Case Number ACP – 324290-26

Lissinagroagh Wind Farm

Response to Submissions Report

FuturEnergy Ireland

Drawing No.: 10955-2033
Revision: A

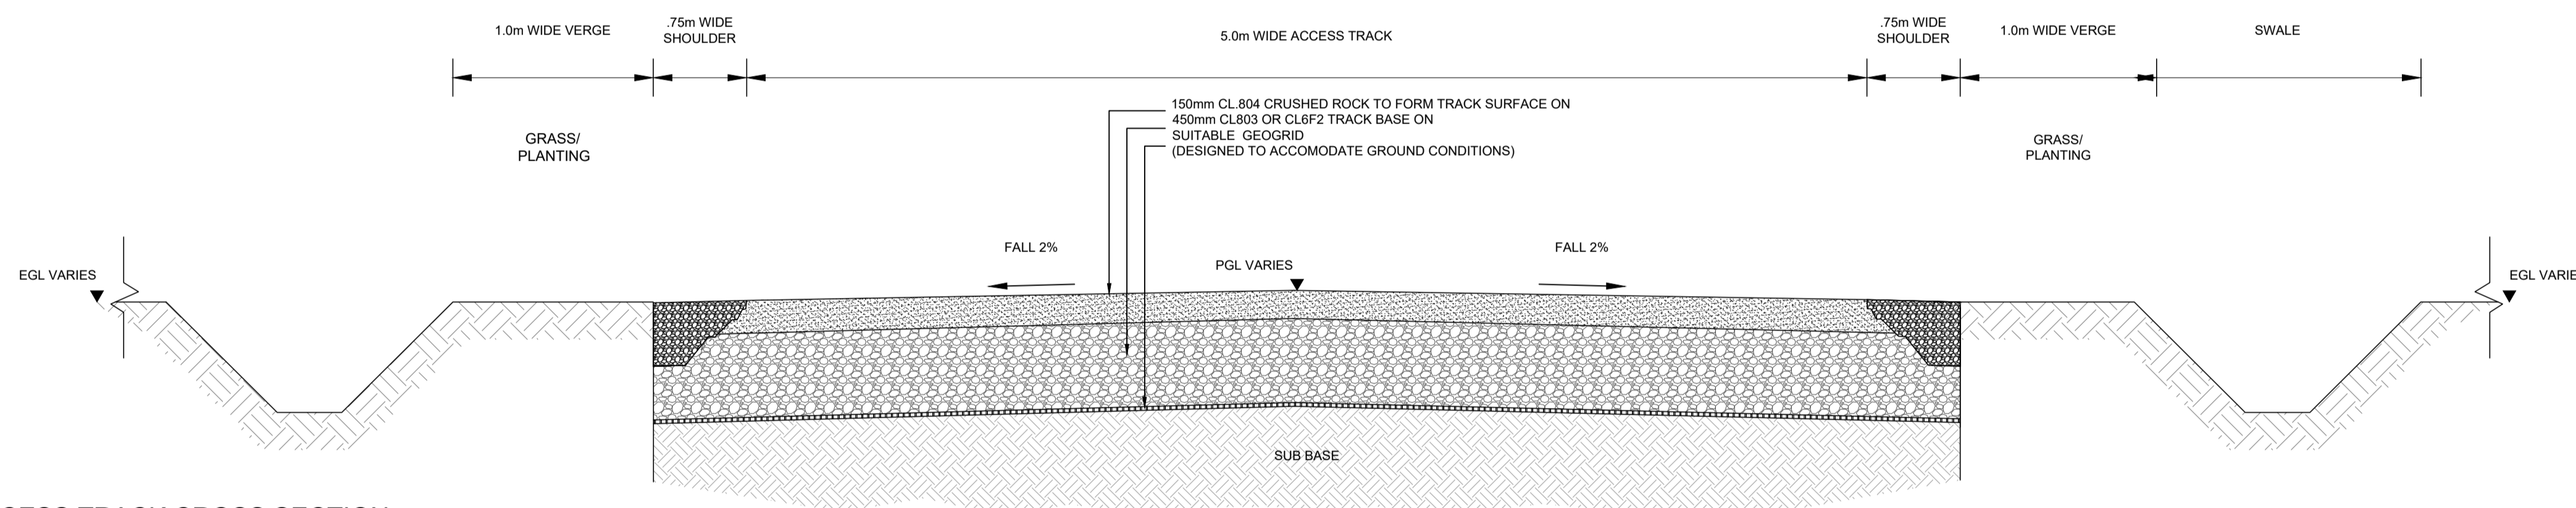
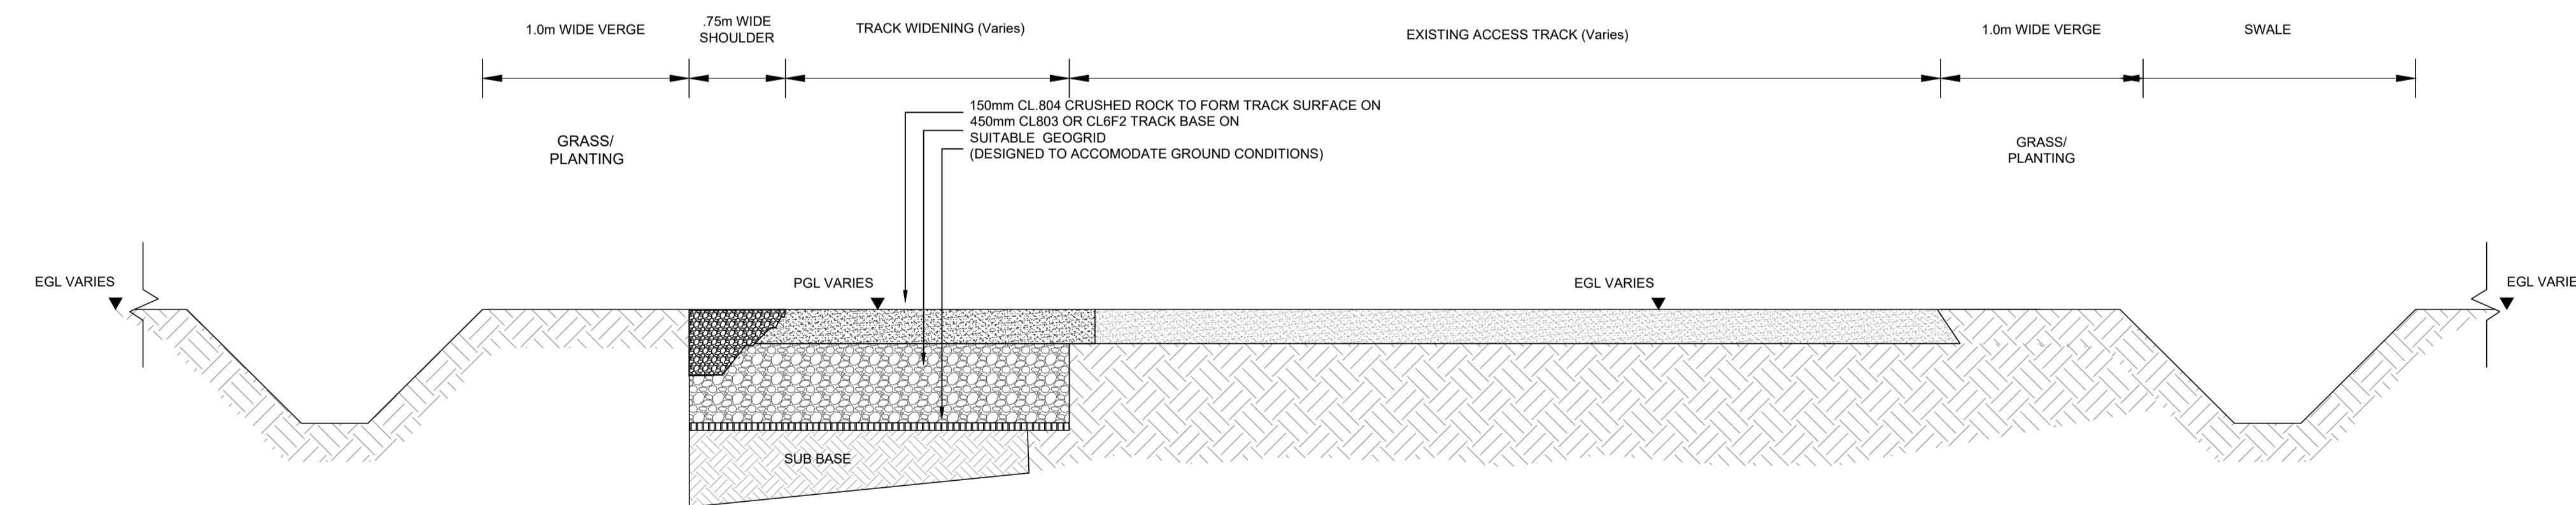
3. *The former drawing referenced in the annotations is a generic drawing titled 'Proposed Track Construction Details'. It refers to 3 types of Access Track – Excavate & Replace; Standard Access Road Construction; and Widening of Existing Track (outside of peat areas). It is assumed that the subject roadway is Type 2 although an EIAR should not rely on a consenting authority having to make assumptions.*

It is confirmed that the road type will be a standard type 2 access track at this location.
